Application for Planning Permission for Works or Extension to a Dwelling

Development: Extension and alteration to existing front porch/garage roof and balcony above and change in external wall finishes to rear and front elevations.
Location: 7 Meadow Way Aldwick PO21 4HG

I regret that I am unable to accept your documents as a valid application until the following item(s) have been received or resolved :-

FRONT (SOUTH WEST) ELEVATION

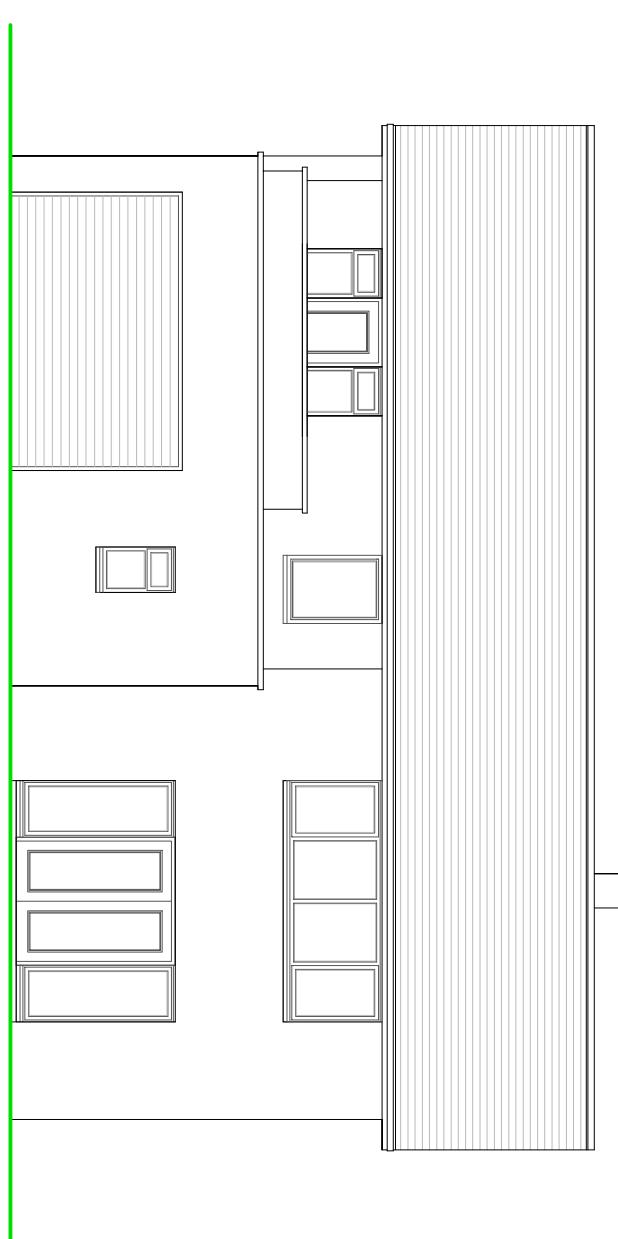
Front Elevations

The existing and proposed front elevations have been labelled as side, please review and amend.
